Our ref: DOC26/158917-13

**EPA Advice on Submissions Report
Mod 3 to Wilpinjong Coal Mine – SSD-6764-Mod-3**

I am writing in response to your request for the NSW Environment Protection Authority (EPA) to review the Submissions Report for the proposed Mod 3 to Wilpinjong Coal Mine for an extension to Pit 8 at 1676 Ulan-Wollar Road, Wilpinjong.

Figure 11: Air Quality Management System

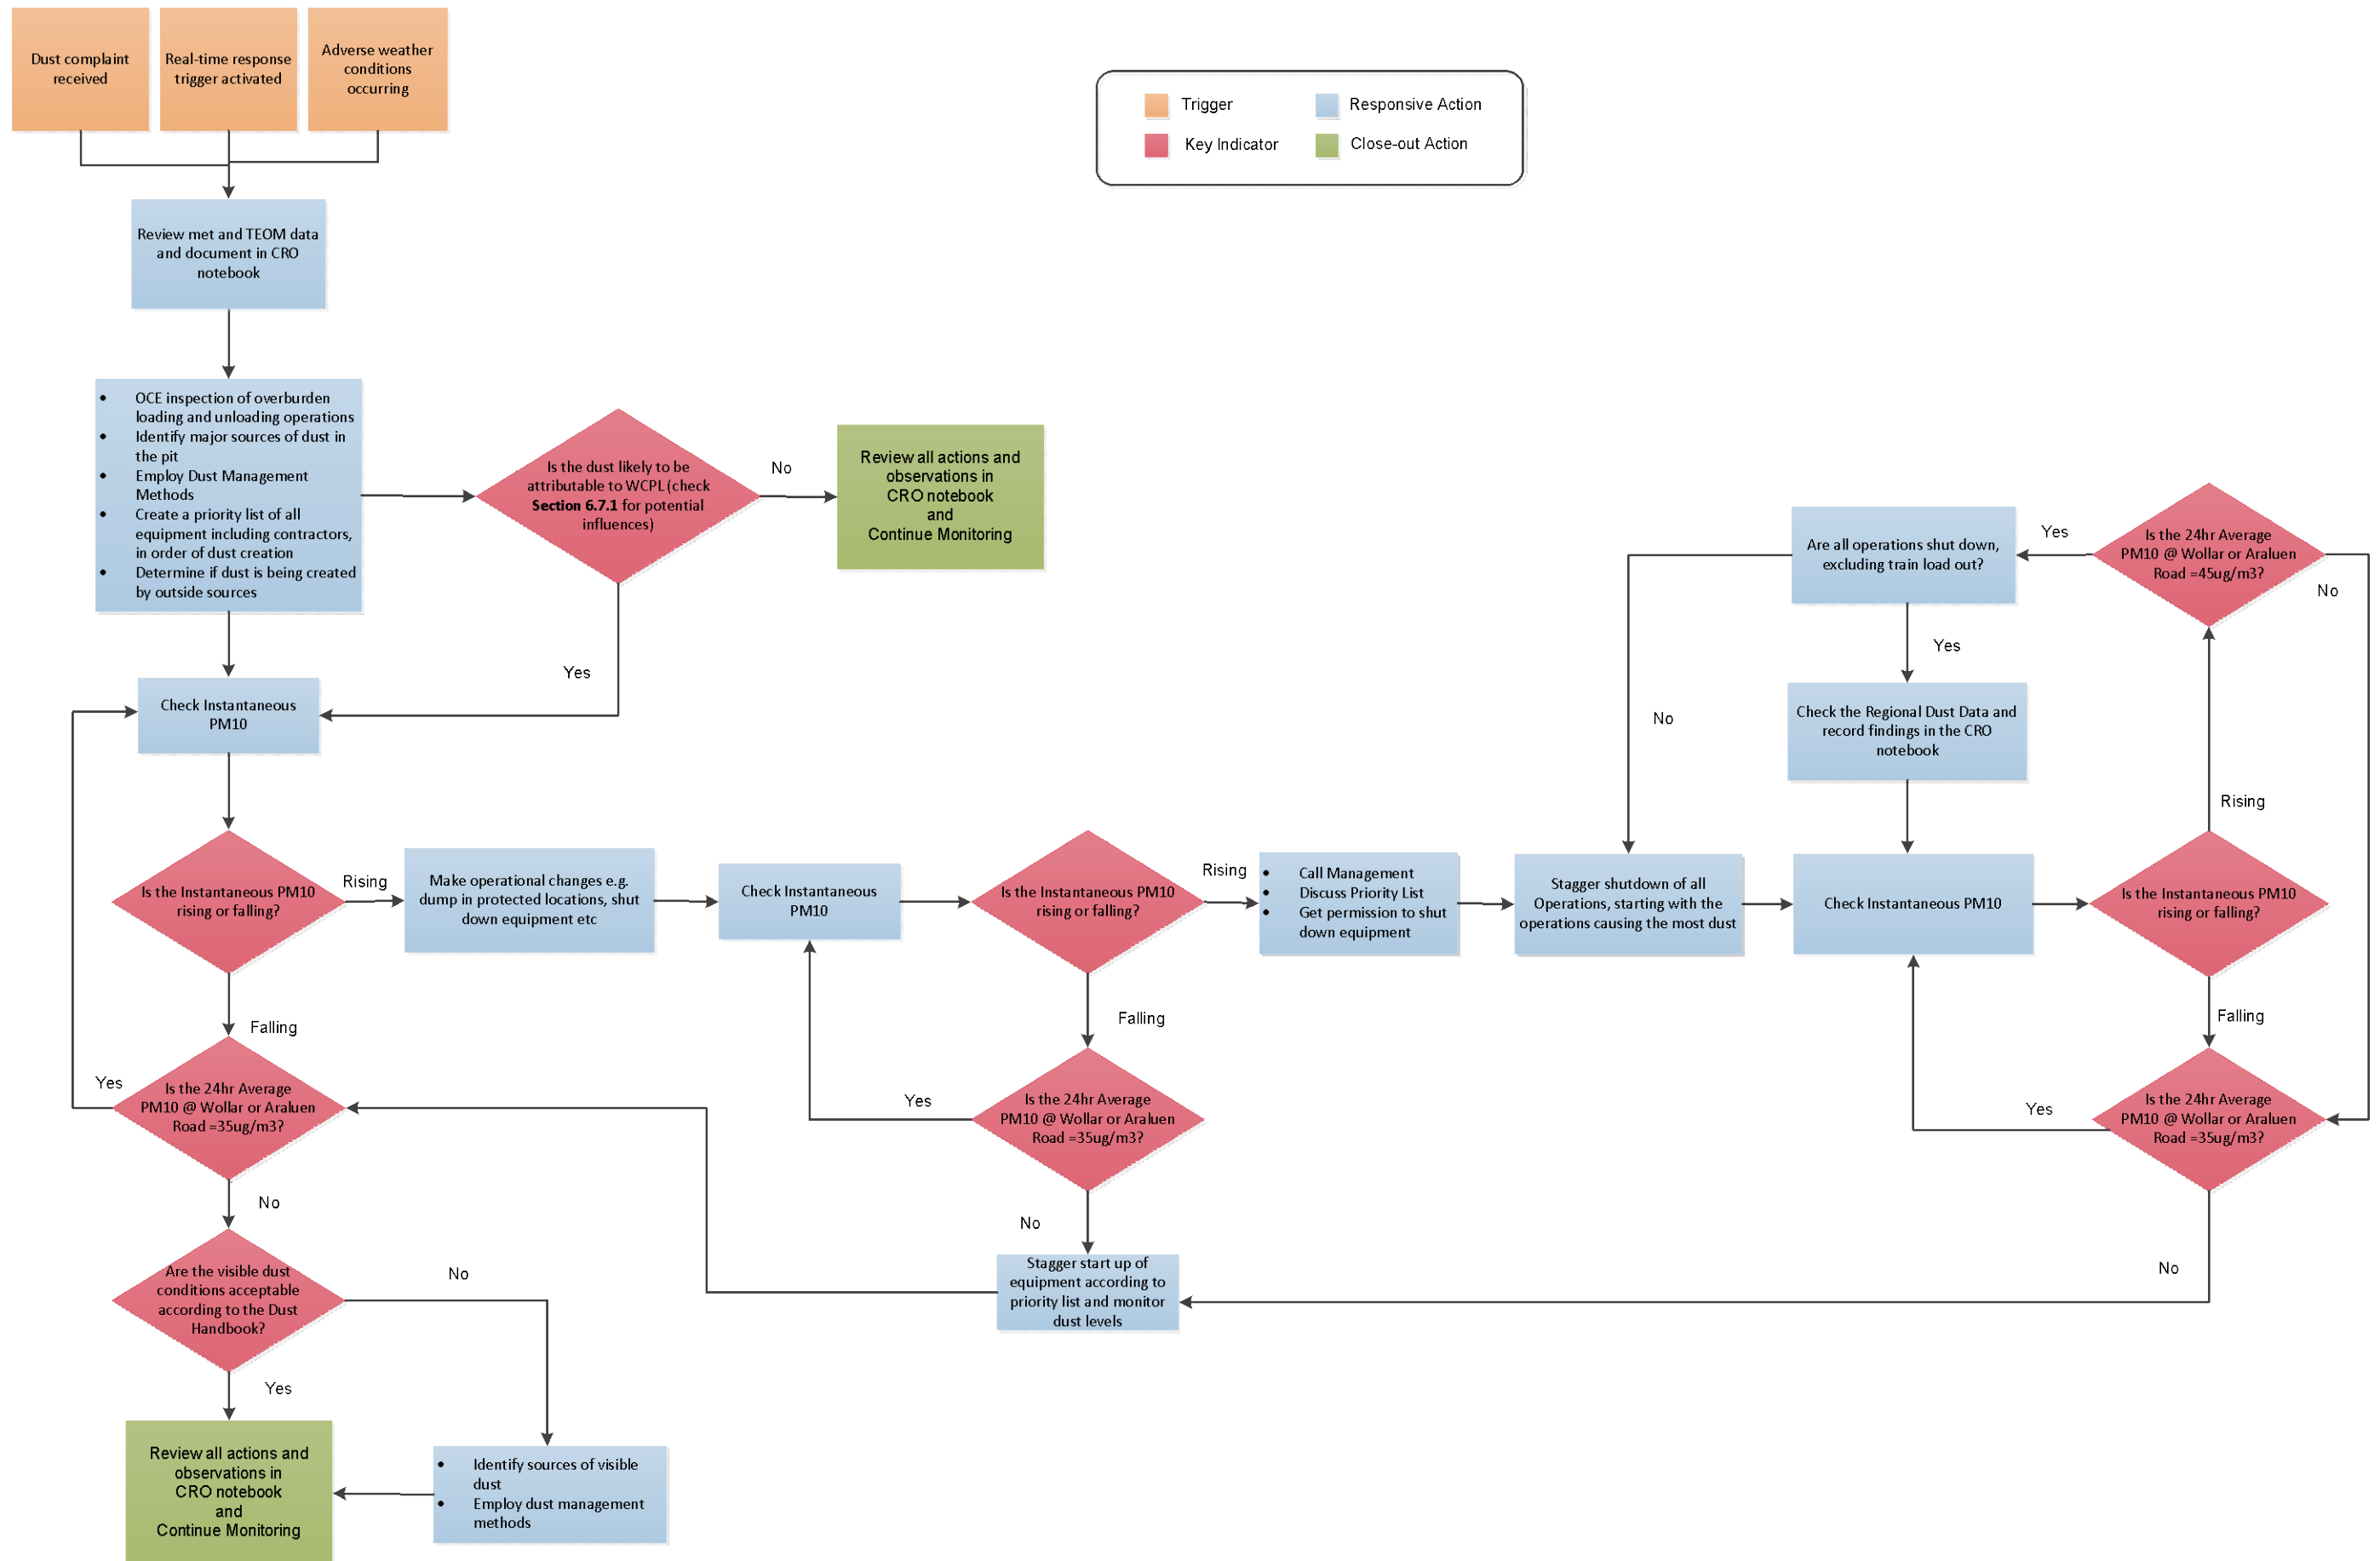
Per figure 11 of the AQMP, one of the initial checks for real time data is a determination whether dust is likely to be attributable to WCPL, and to check section 6.7.1 of the AQMP for potential influences. Section 6.7.1 states that where monitoring indicates an exceedance of the Air Quality Criteria, it is necessary to establish if the exceedance was a non-compliance by assessing whether the monitoring data was influenced by either extreme events, irregular activities, or if the data is reasonable. It is further stated that a non-compliance is deemed to have occurred where an exceedance is solely caused by particulate matter being generated from the mine.

The EPA notes it is unclear what type of assessment would be conducted to determine whether dust measured (as part of the mine’s ambient network) is attributed/ solely attributed to the Wilpinjong Coal Mine.

The EPA advise that the AQMP lacks clarity regarding the following:

- The adopted methodology for how measured dust is attributed to either the Wilpinjong Coal Mine, or external sources and,
 - If the above methodology is consistent with demonstrating that no additional exceedances of the impact assessment criteria will occur as a result of the proposed activity.
- iii. The AQMP does not include adequate definitions for adverse weather conditions:

Recommendation: The Proponent must demonstrate that no additional exceedances will occur due to the Proposal. The Proponent may consider refining their trigger action response plan / AQMP to demonstrate that no additional exceedances will occur due to the Proposal. The Proponent may consider (but are not limited to) the following measures regarding additional refinement of their AQMP:

- The Proponent may consider updating the AQMP to include a trigger action response plan (TARP) into the AQMP for PM_{2.5}.
 - The Proponent should:
 - o Clearly describe the method used to attribute measured dust to either Wilpinjong Coal Mine or other external sources.
 - o Demonstrate how the proposed methodology (under ii a.) is consistent with the requirements outlined in the Approved Methods i.e. demonstration that no additional exceedances of the impact assessment criteria will occur as a result of the proposed activity.
 - The Proponent should clarify triggers under the AQMP to ensure that they are sufficiently clear to allow for prompt activation during a dust event. This may include further defining “adverse weather conditions”.
- b. Update information provided in cumulative assessment
